Ref: 167  
21 October 2022

### Blind Creek Solar Farm – Response to Agency Comments

Amber Organisation has been asked to provide a review and response to the agency comments received in relation to the Blind Creek Solar Farm. The comments received from Transport for NSW and Queanbeyan-Palerang Regional Council, and the associated response, are provided below.

Figure 1-19 Development site access

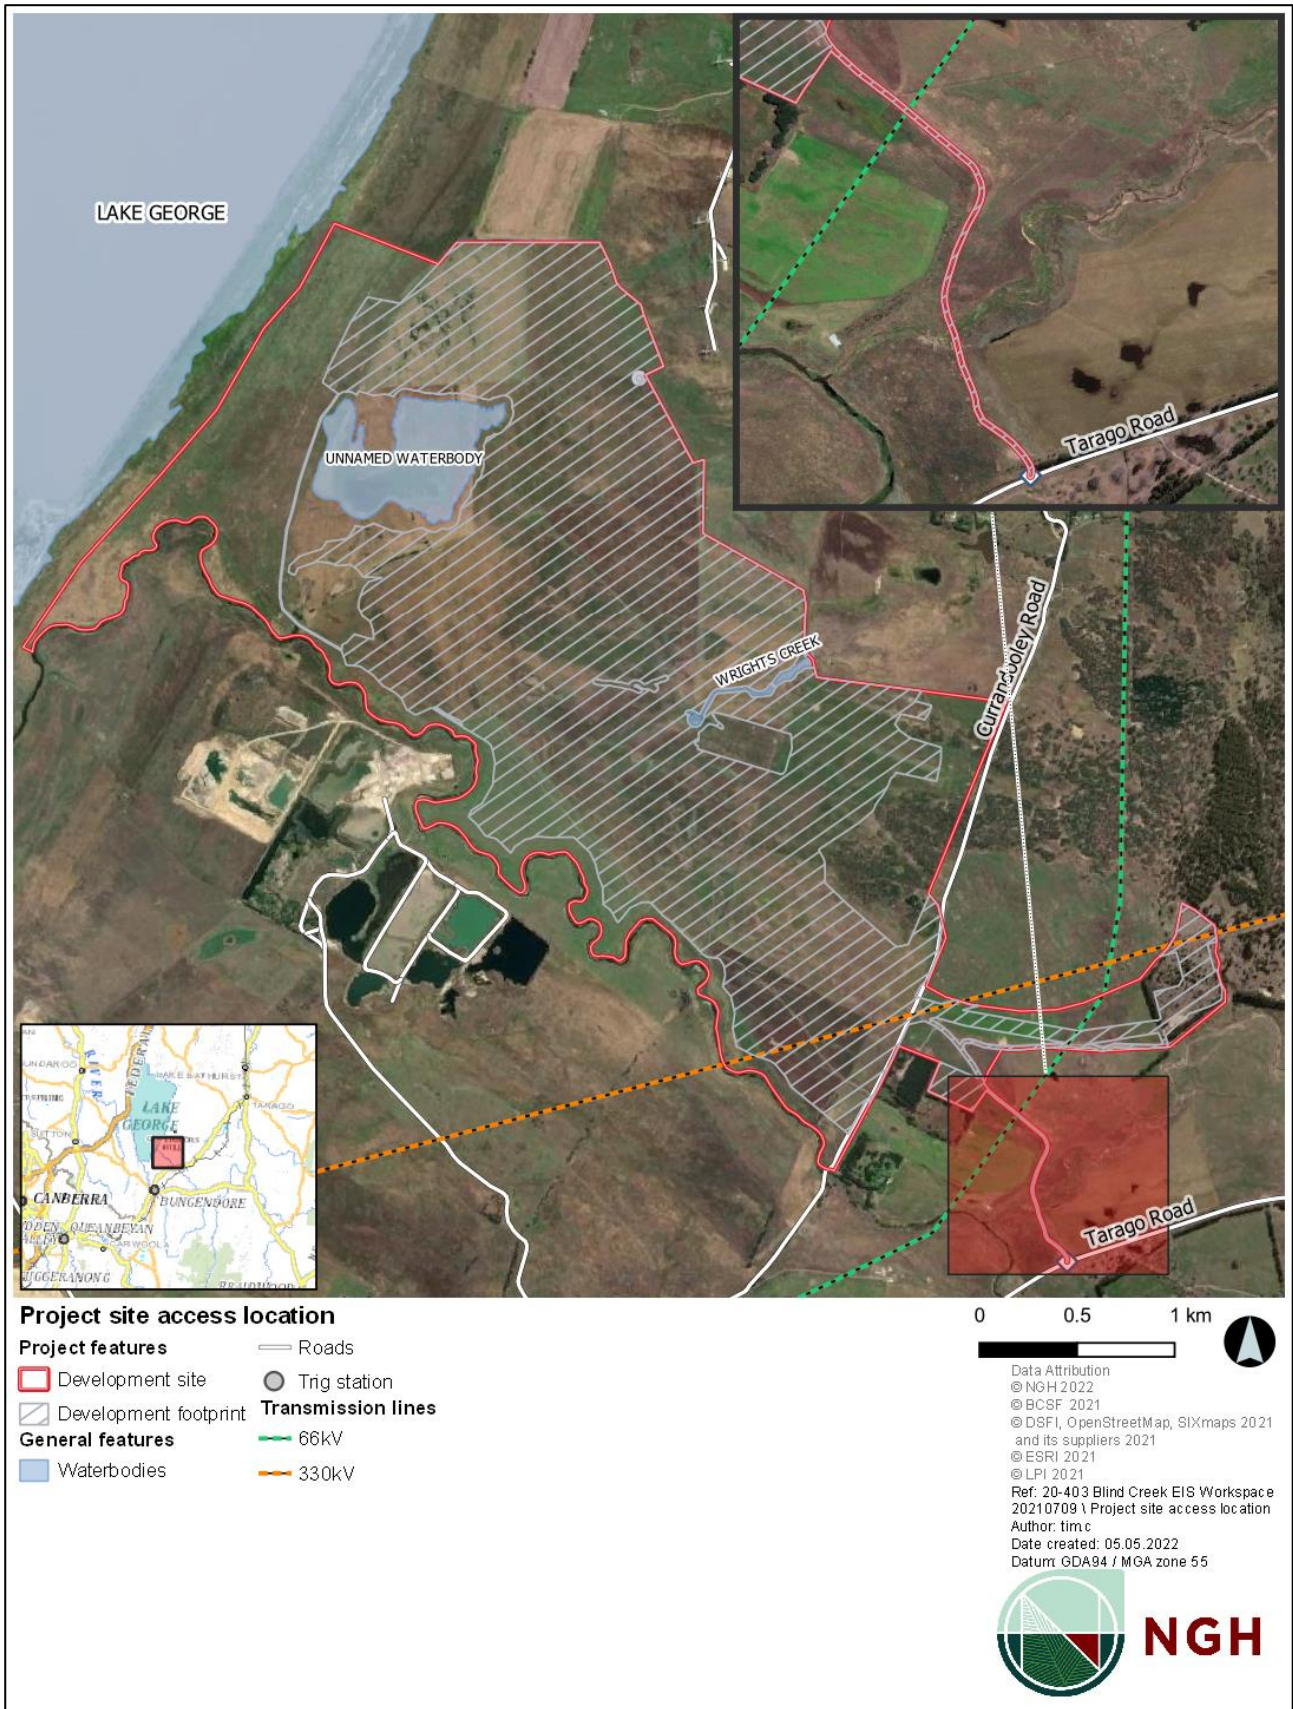
Comment	Response
Transport for NSW	
The length of the BAR treatment should be extended to comply with Figure A 28 of Austroads Guide to Road Design Part 4. The length for the turning path (X) should be added and the tapers should be designed for a design speed of 110kph.	Detailed design drawings for the site access have been prepared by PHL Surveyors. The design shows a BAR treatment in accordance with the Austroads Guide. The detailed design drawings have been provided within Appendix A.
The table drains on both sides of Tarago Road will have to be reinstated. Cross sections will be required to confirm the roadworks can be contained within the road reserve.	The detailed design plans are understood to have addressed this matter.
TfNSW notes only the section shown in Attachment 3 is approved as a B-double route but the intention is to use B-doubles during construction and deliveries. Clarification is required as to how the applicant intends to utilise B-doubles noting the above.	The use of sections of road that are not rated to accommodate B-Doubles is typically subject to specific permit application process that occurs following approval of the planning permit. As such, it is understood that this matter will be addressed prior to construction as part of the permit process.
